From: Simon Davis
Sent: 21 December 2017 15:43
To: Planning.Responses
Subject: FW: Pevensey Road BR/229/17/PL

Further Drainage response

DRAWING TITLE	
Proposed Site Plan	
DATE	SCALE
Feb 18	1:200 @ A1
JOB NO.	DRAWING NO.
1615	2.10
	REVISION
	CHECKED BY
	GIM

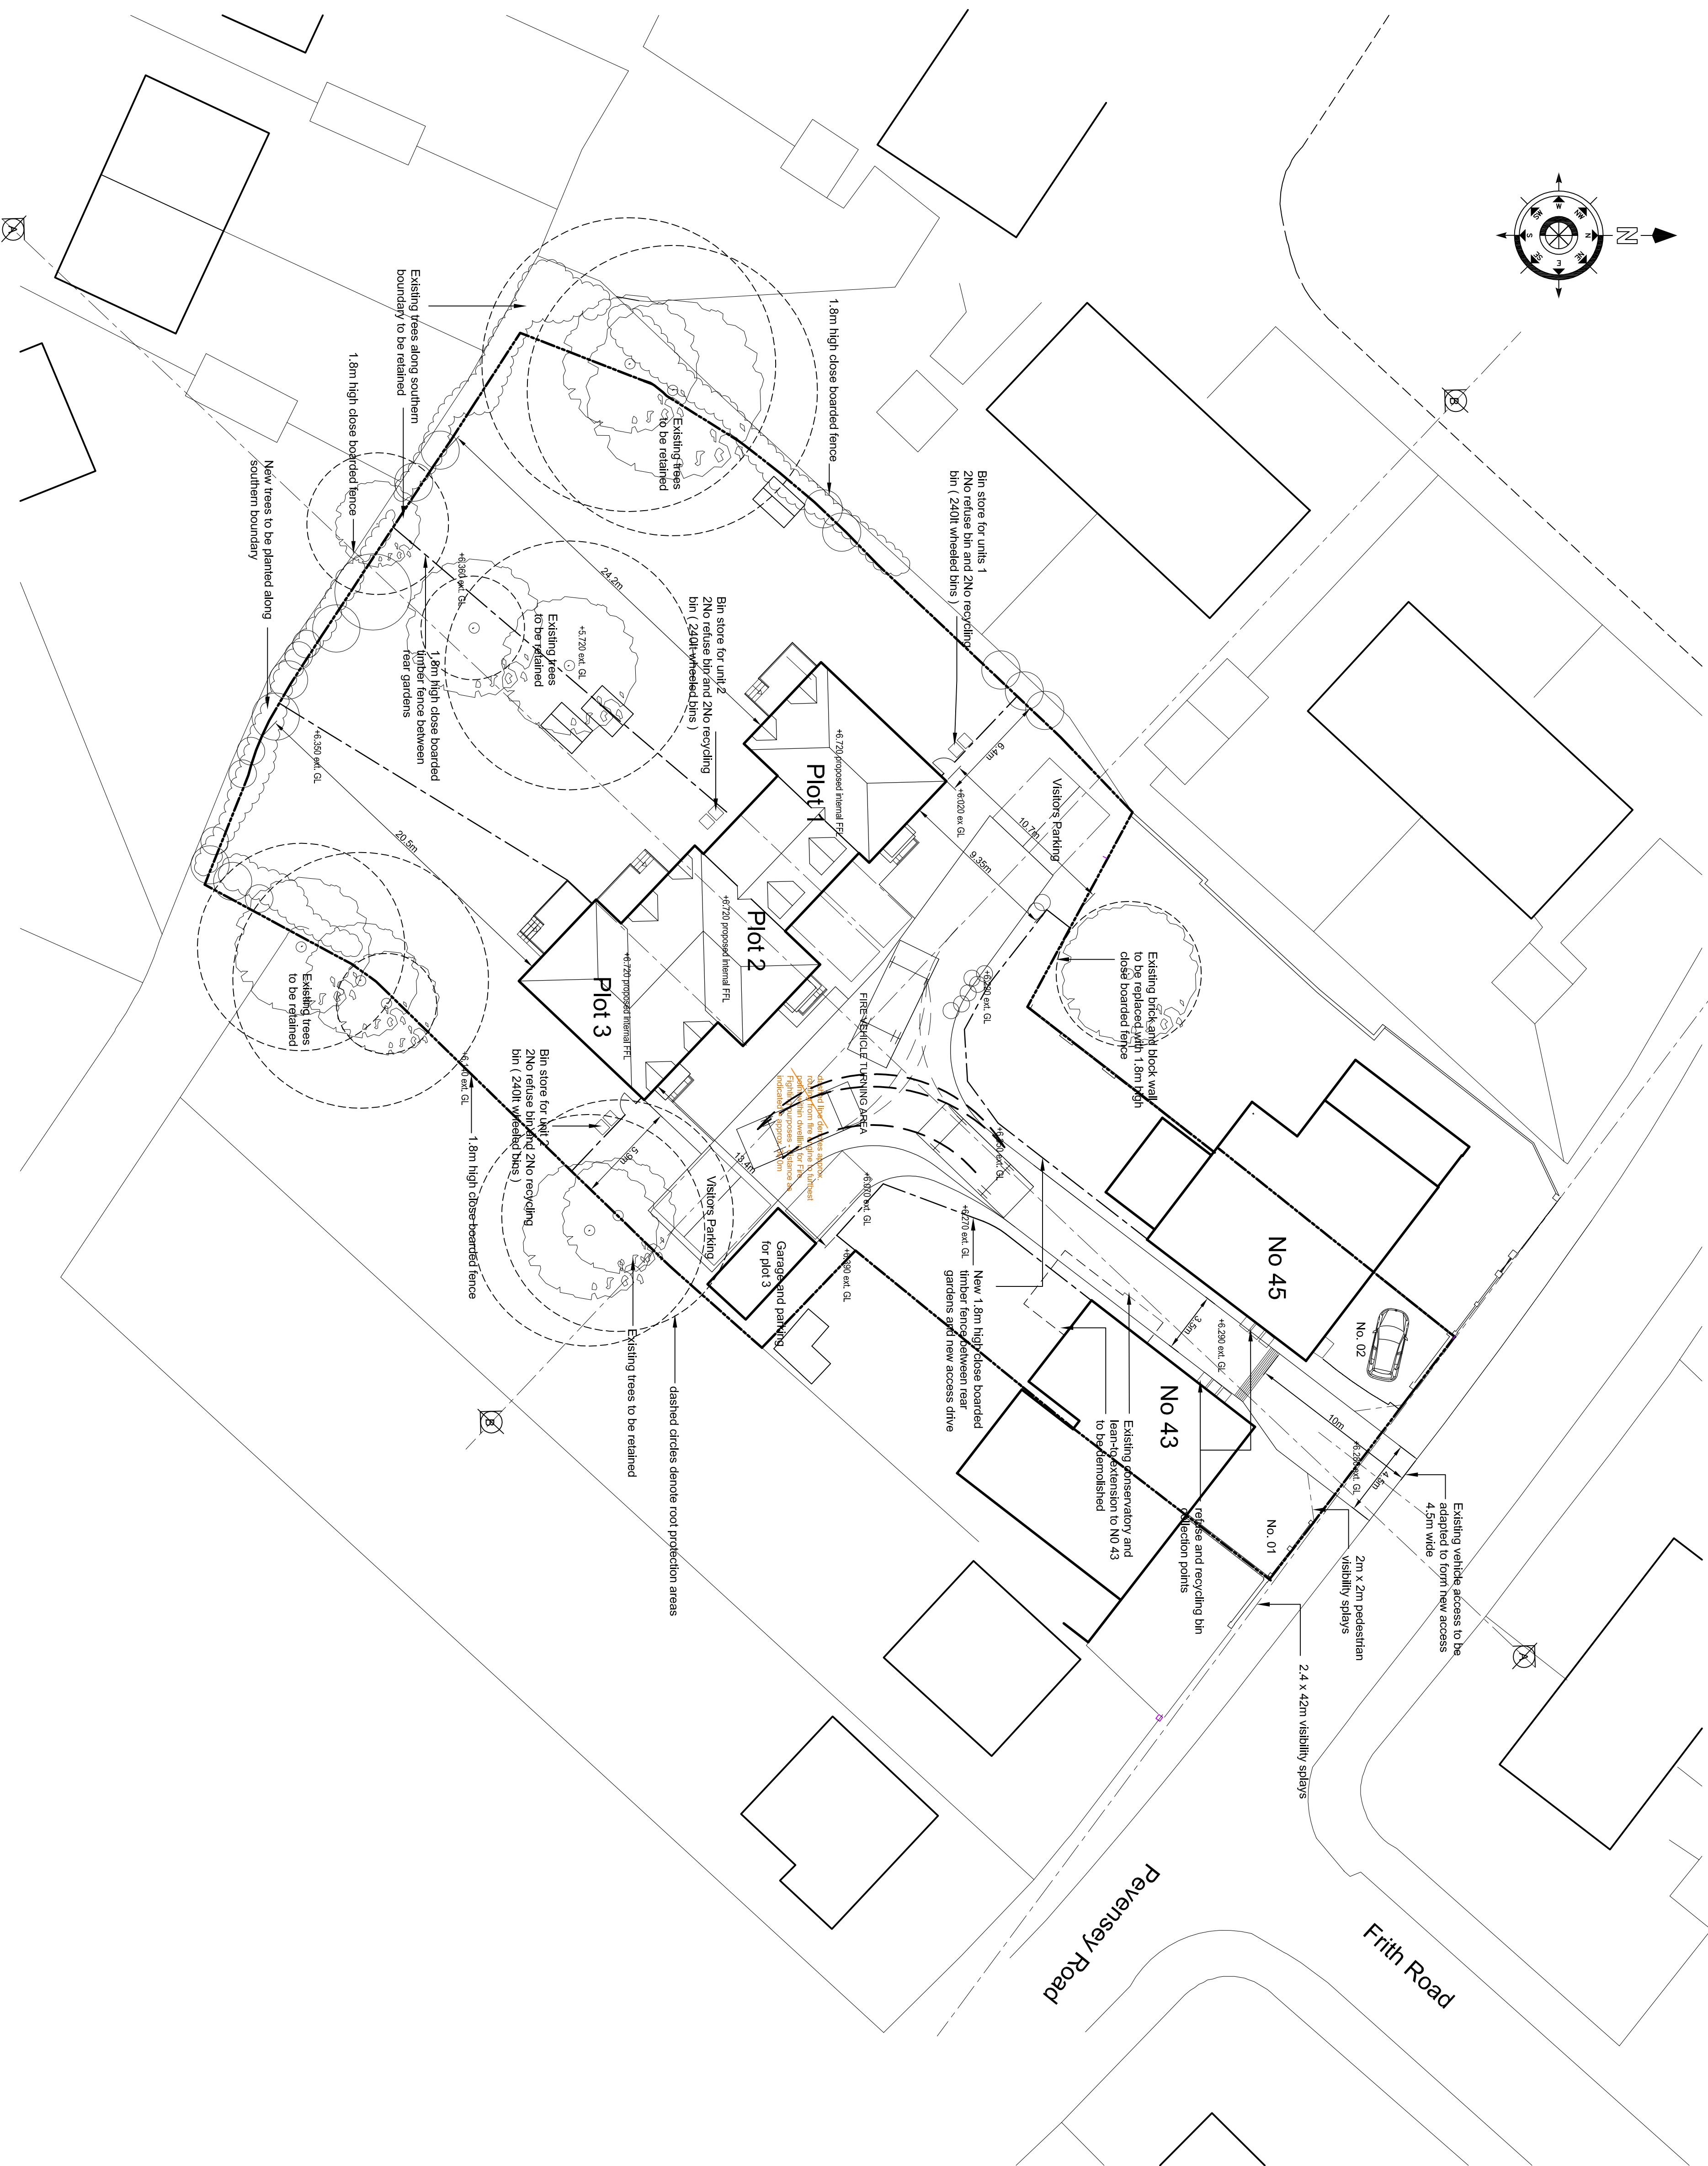
As discussed, the applicant will need to provide suitable drawings (plans/sections/construction details/topographical survey) to prove that there will be no loss of flood storage. Calculations are also required to support this.
